WEST SUSSEX COUNTY COUNCIL CONSULTATION

TO:	Arun District Council FAO: Anita Gardner
FROM:	WSCC - Highways Authority
DATE:	19 July 2019
LOCATION:	Stoney Brook Farm, Eastergate Lane, Walberton
SUBJECT:	WA/61/19/PD Notification for Prior Approval under Part 3, Class O for change of use from an office (Class B1) to 1 No. dwelling (Class C3).
DATE OF SITE VISIT:	N/A
RECOMMENDATION:	Advice
S106 CONTRIBUTION TOTAL:	N/A

Drawing 4 - Illustrative
Proposed Part Ground Floor Plan

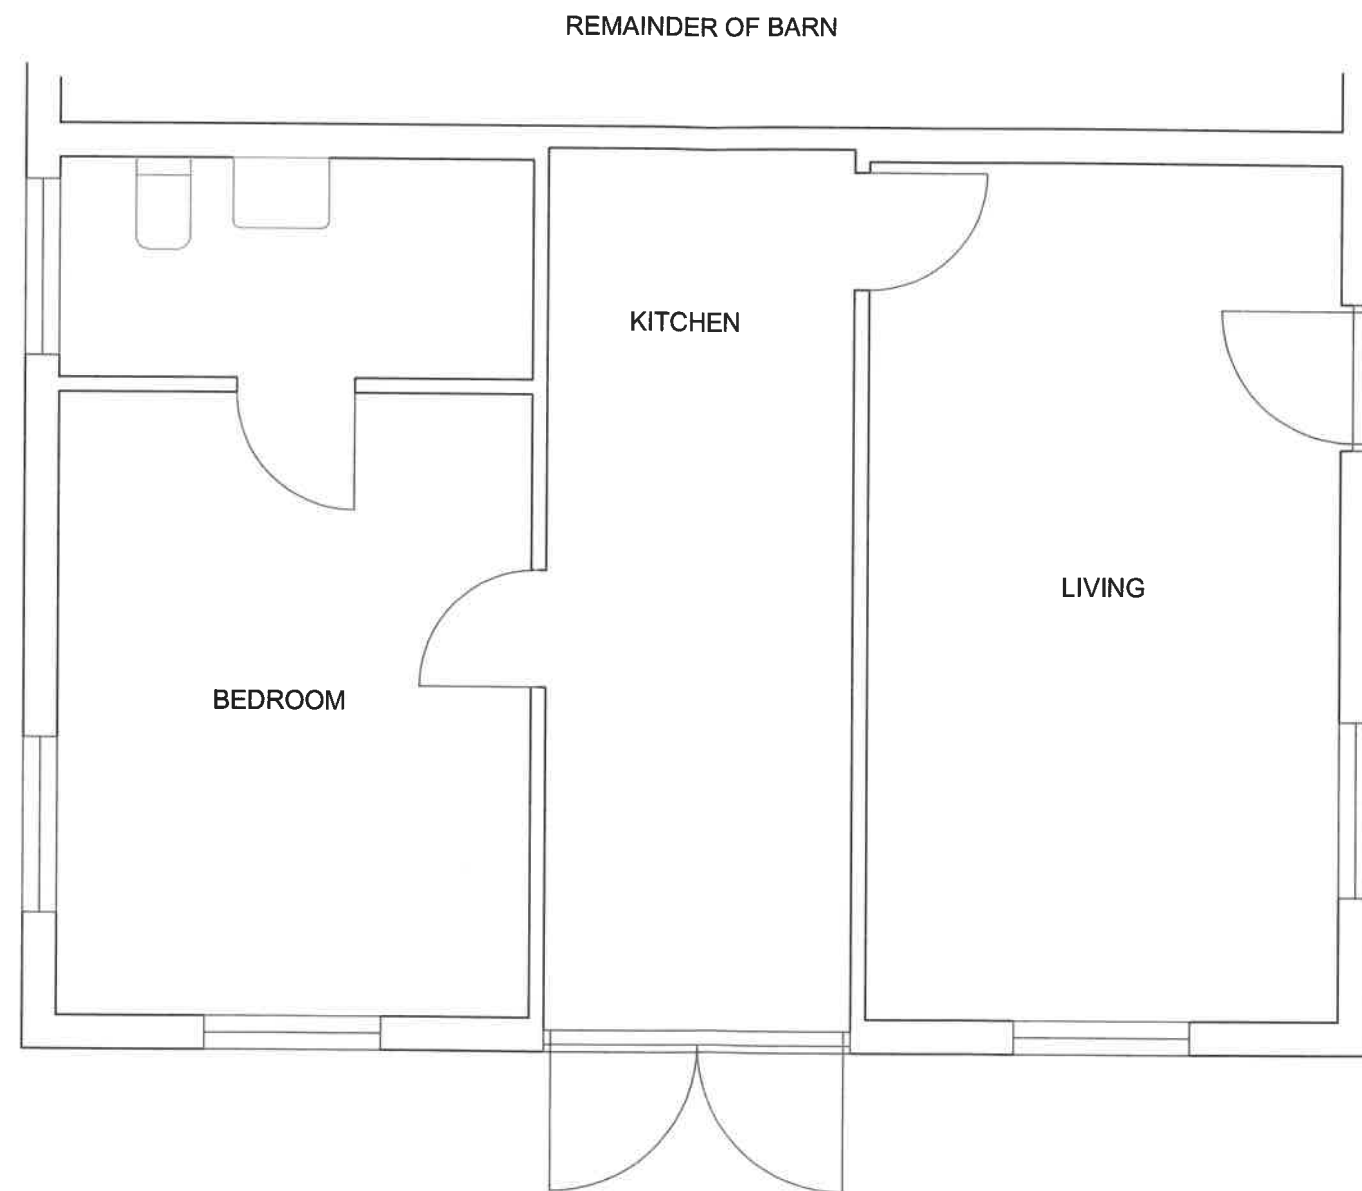
The plans do not demonstrate parking provision for the proposed dwelling. The WSCC Car Parking Demand Calculator indicates that a dwelling of this size in this location would require at least 1 car parking space. There appears to be sufficient space on site for this demand to be met. The LHA would recommend that secure and covered cycle parking is provided for the dwelling in order to encourage sustainable transport methods.
